Our Ref: BE/3/20/HH
Your Ref:

Town & Country Planning Act 1990 (as amended)
Town & Country Planning (Development Management Procedure) (England) Order 2015
Application for Planning Permission for Works or Extension to a Dwelling

Development Two storey side extension
Location 3 Central Avenue Bersted

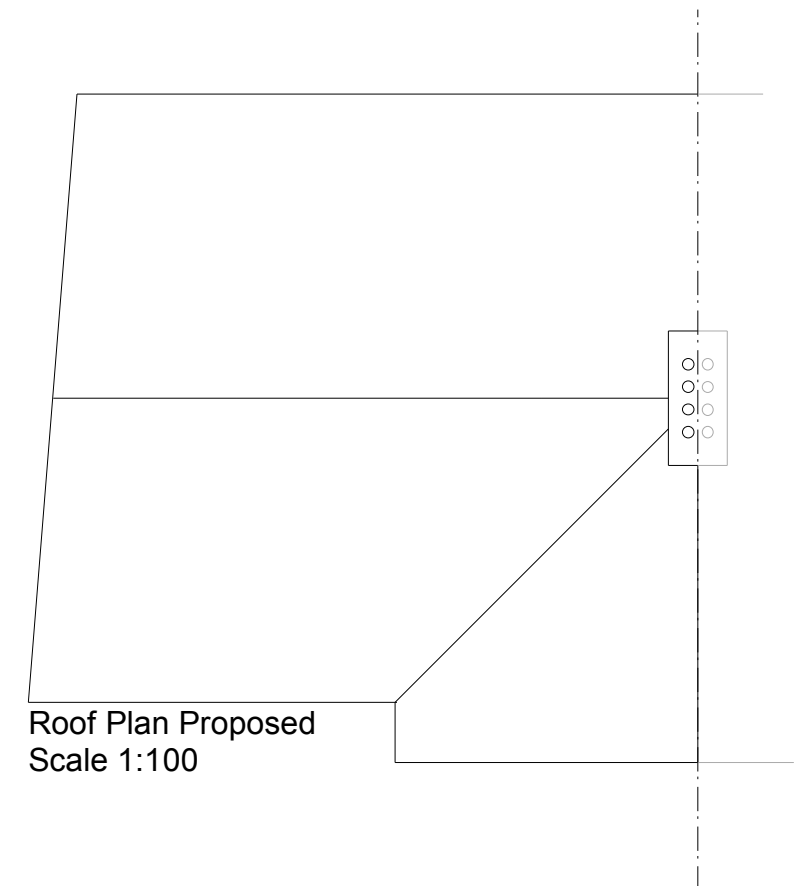
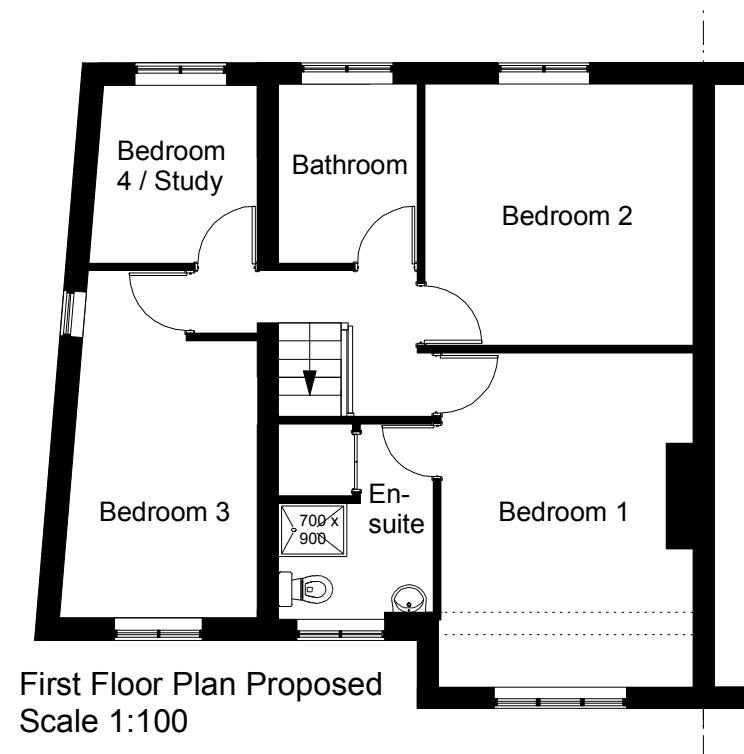
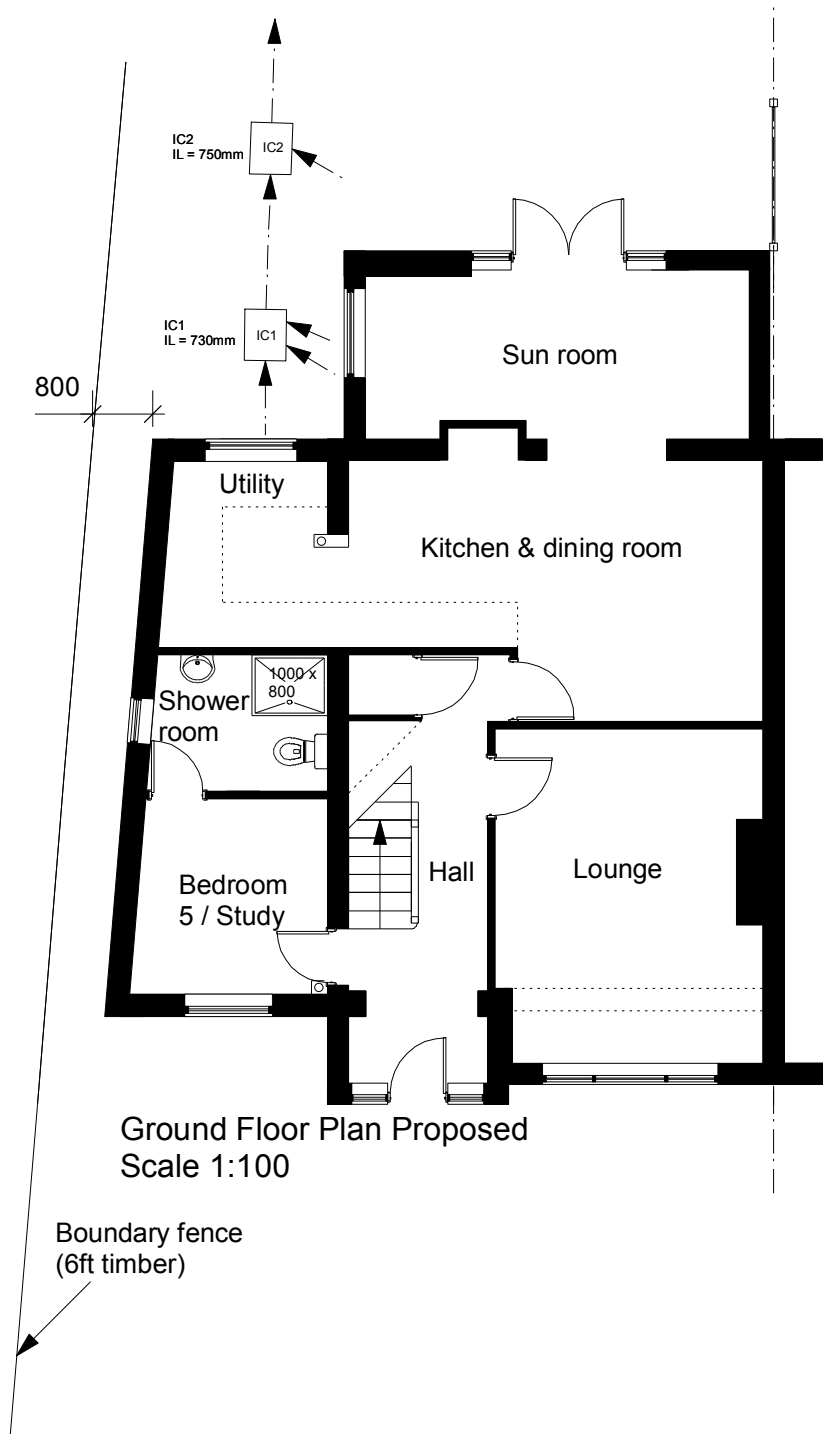
Inconsistent: The size and shape of the extension is inconsistent between the block plan and proposed plans.

Location (Block) Plan (Extract from Ordnance Survey)
Scale 1:500
Outlined in red shows the boundary of 3 Central Avenue.
Outlined in blue shows position of extension.

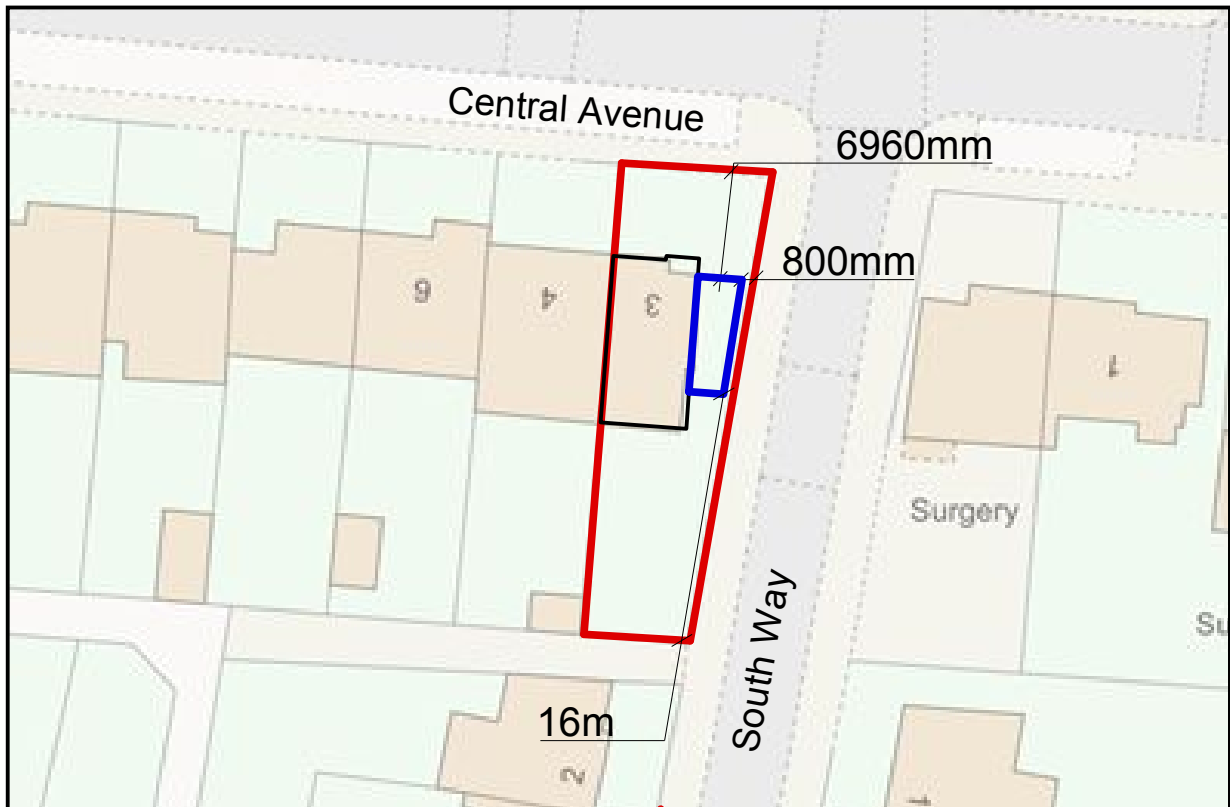
Block Plan: You are required to have dimensions to all site boundaries. Currently the one to the rear boundary is missing, please amend or with your permission we can add it for you.
